Norfolk Boreas Offshore Wind Farm Schedule of Changes to the draft Development Consent Order (Version 3)

Applicant: Norfolk Boreas Limited
Document Reference: ExA.SCh.D4.V3
Deadline 4

Date: January 2020
Revision: Version 3
Author: Womble Bond Dickinson

**APPENDIX 2: SLIDES SHOWING ONSHORE PROJECT SUBSTATION
INFRASTRUCTURE (AGENDA ITEM 4 (b) I)**

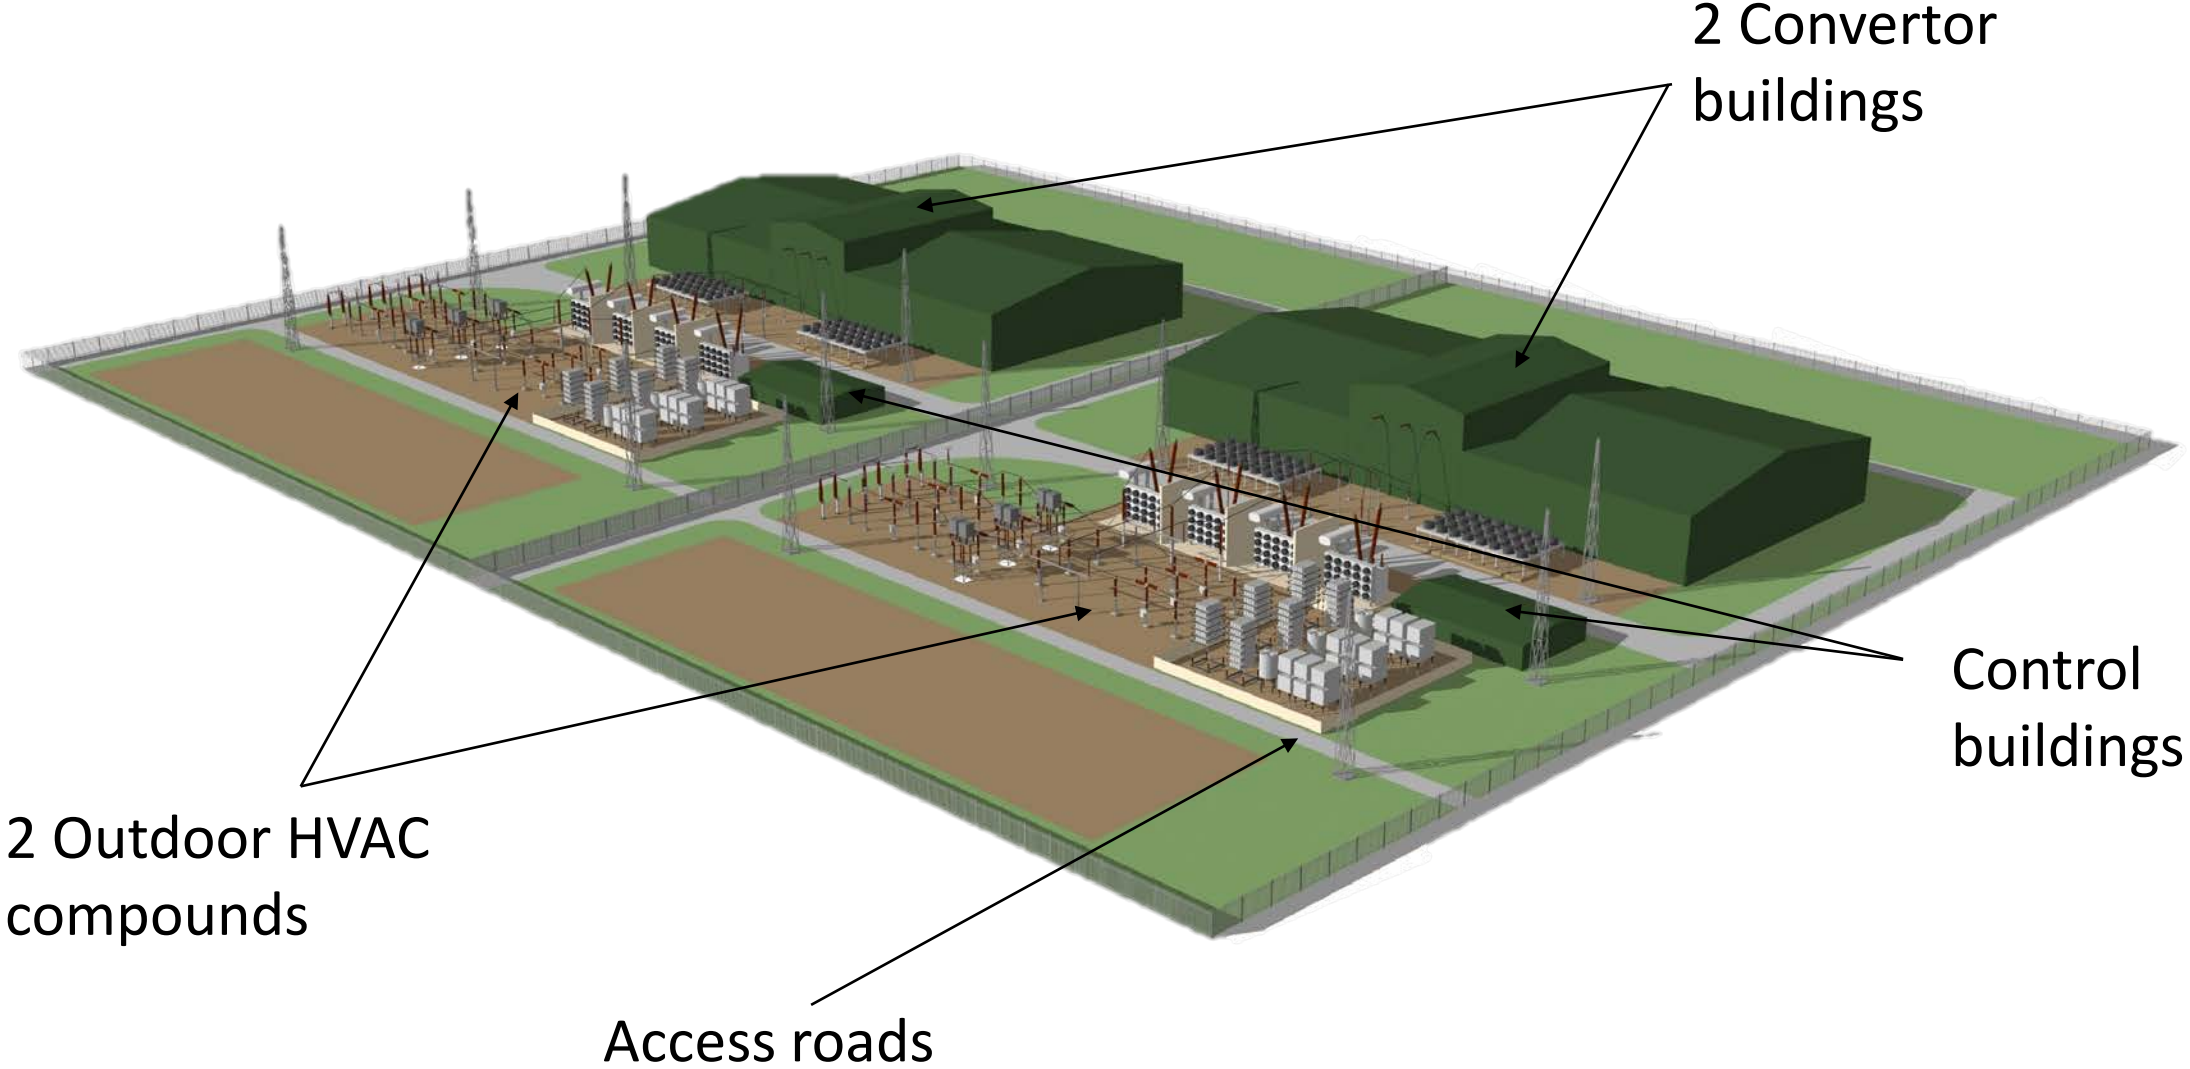
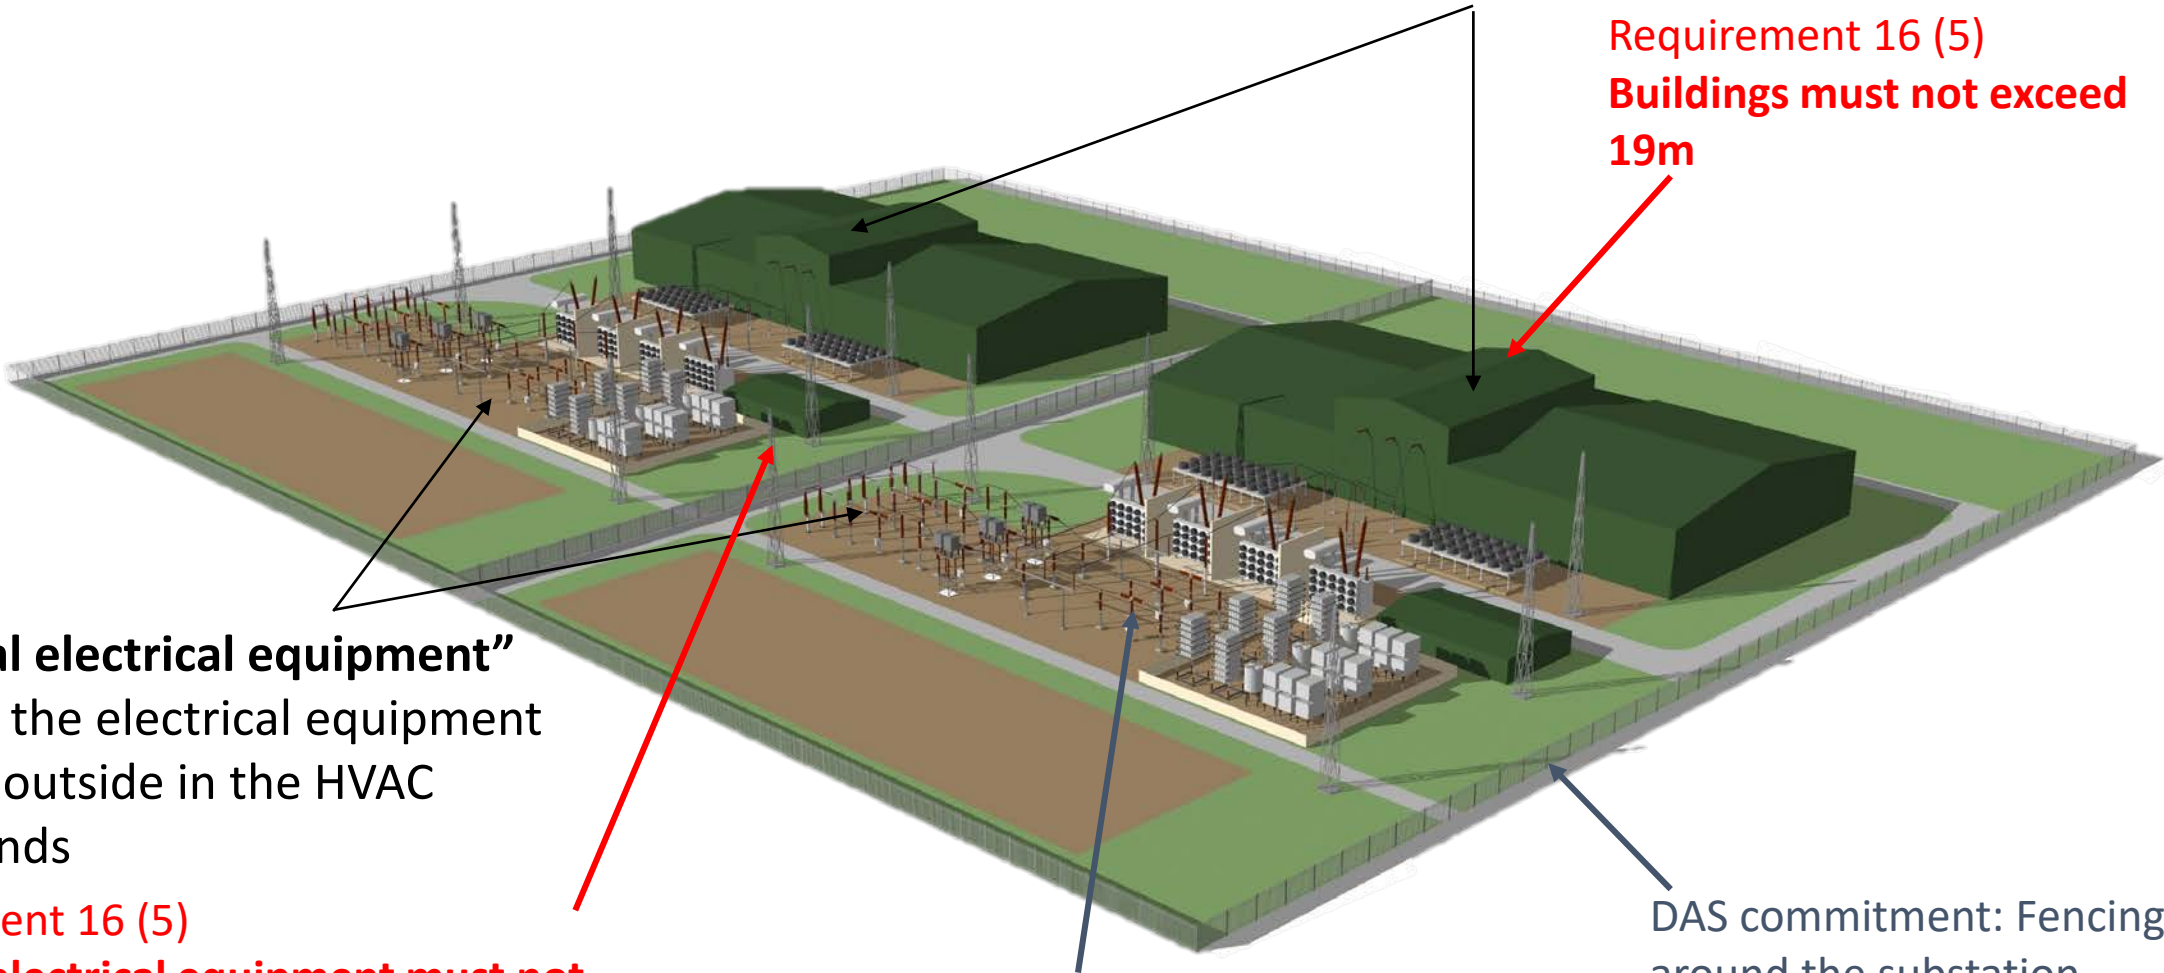
Ref.	DCO Ref.	Consultee	Comments from consultee (Rationale for the change)	Change made	DCO Version
Deadline 4 (30 January 2020)					
39.	Article 2, Interpretation	ExA	At the hearing into onshore matters held on 21 January 2020, the ExA asked for clarity on the buildings connected to the onshore project substation. The Applicant has therefore inserted a new definition for converter building at Article 2 and referred to converter building in Requirement 16.	<i>"converter building means the building housing the principal electrical equipment comprised in Work No.8A"</i>	4

50.	Requirement 16	ExA	At the hearing into onshore matters held on 21 January 2020, the ExA asked for clarity on the buildings housing the principal electrical equipment. The Applicant has therefore inserted a new definition for converter building at Article 2 and referred to converter building(s) in Requirement 16.	16.—(1) <i>The total number of converter buildings housing the principal electrical equipment for the onshore project substation comprised in Work No. 8A must not exceed two.</i> (2) <i>Construction works for the onshore project substation buildings referred to in paragraph (1) above must not commence until details of the layout, scale and external appearance of the same have been submitted to and approved by the relevant planning authority.</i> ... (5) <i>Buildings (including the converter</i>	4

Ref.	DCO Ref.	Consultee	Comments from consultee (Rationale for the change)	Change made	DCO Version
				<p><i>buildings) comprised in Work No. 8A must not exceed a height of 19 metres above existing ground level and external electrical equipment comprised in Work No. 8A must not exceed a height of 25 metres above existing ground level.</i></p> <p><i>(6) The total footprint of each converter building housing the principal electrical equipment for the onshore project substation comprised in Work No. 8A must not exceed 110 metres by 70 metres.</i></p>
